My name is Bill Parker. I have lived in East Suffolk for more than 20 years and I was Head of Coastal Management for East Suffolk Council for 7 years until 2019.

The areas that I would like to specifically comment upon are: the failure of EDF to be precautionary, flaws in the proposed coast defence solution, questions on the use of science and the long-term legacy to future generations.

Soft coast defence explanation as requested by Mr Brock.

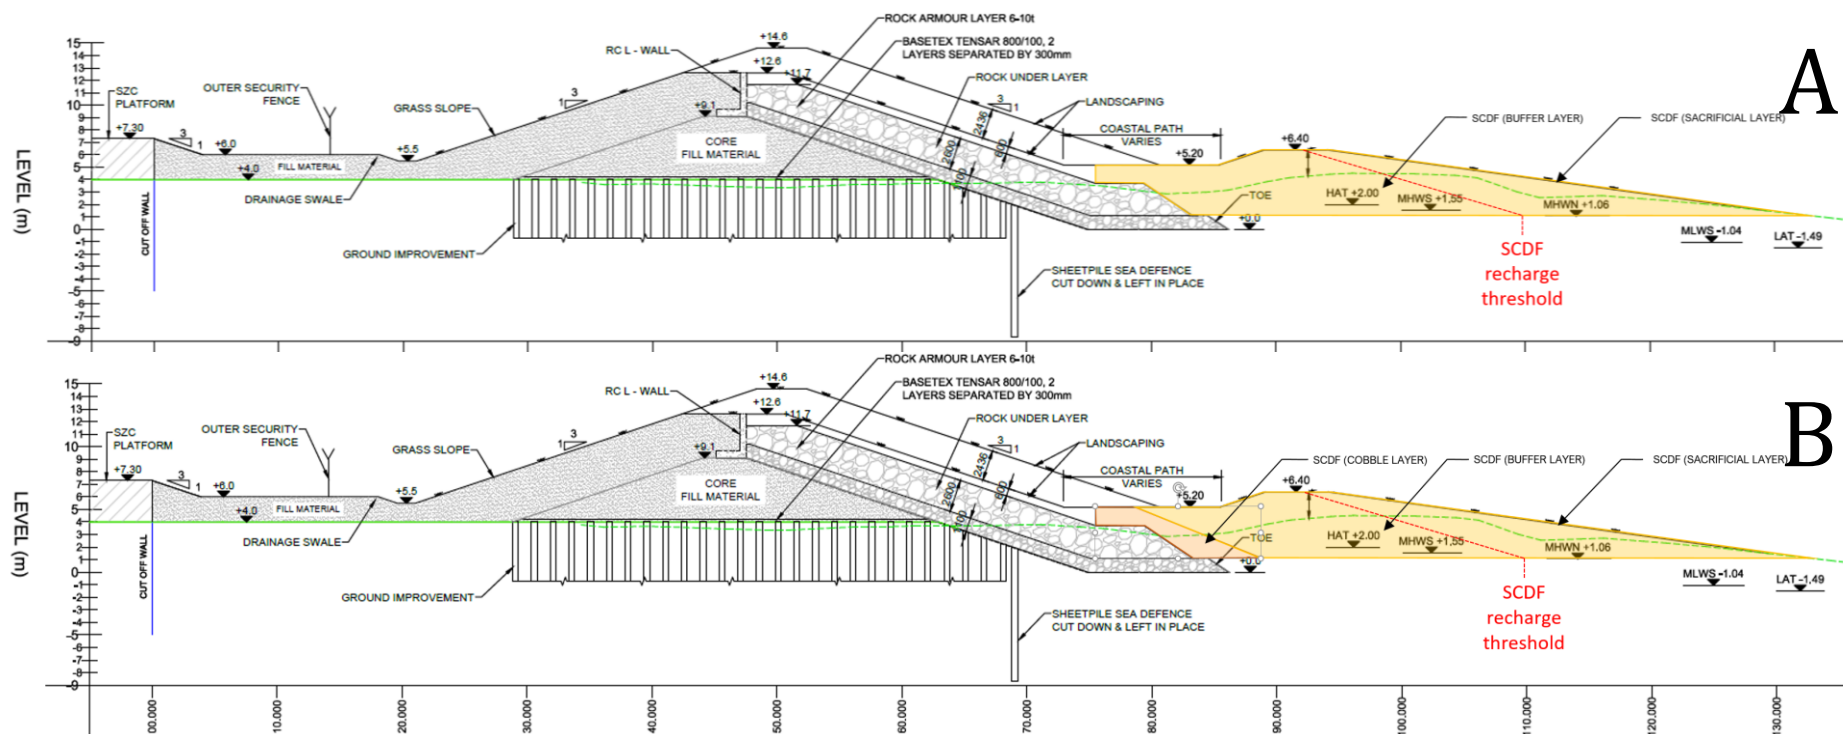
EDF have yet to submit detailed designs for the coast defences and have therefore avoided critical examination by others. But the outline proposal does identify the use of soft defences. This would require the deposition of huge amounts of dredged marine material to act as a sacrificial beach. This approach is based on the Dutch Zand Motor (see appendix 1) which is barely 10 years old, yet these defences are expected to defend the site and the nuclear waste for perhaps 140 years. It is a novel solution but there is no evidence that this location is suitable for this approach, no experience of how to deal with rapid sea level rise, no clarity on who would fund its maintenance, no assessment of the impact on adjacent coastlines and no proposals for a plan B if this doesn't work.

The submission by the applicant includes an outline proposal for soft coast defence. In the TR523 Coastal Processes Monitoring and Mitigation Plan (CPMMP) page 34 it outlines a number of approaches to maintaining the beach in front of the hard defences to prevent them from being exposed to wave attack and interrupting natural coastal processes which would accelerate erosion to the north and/or the south of Sizewell C.

These are well known coastal management techniques but they are only a short-term solution to a symptomatic problem. This could have to be repeated as frequently as required. It is however entirely dependent on the availability of excess sediment material and the ability to access both those areas of surplus and the areas with a deficit of material. They are not a robust long term solutions especially when considering increasing sea levels which means that the availability of surplus material is much less likely.

When considering the use of sandscaping as with other interventions, it cannot be seen as a one-off intervention and will require effort and cost to ensure it remains an effective coast defence. There are also consequences (in particular environmentally) both down drift and sub-tidally that should be examined in detail now and taken into account. As in the above submission there are many unanswered questions about the viability of this approach.

The weakness with the CPMMP is that it is a reactive approach, is that if sandscaping or any other intervention is required then the regulatory authorities have little choice but to give approval whatever the collateral impacts as the consequences of not supporting a proposed approach to protect a nuclear power station would be catastrophic. The recognition by EDF / Cefas that the proposed use of soft defences is a clear indicator that this is not a suitable site to build a such a vulnerable infrastructure.
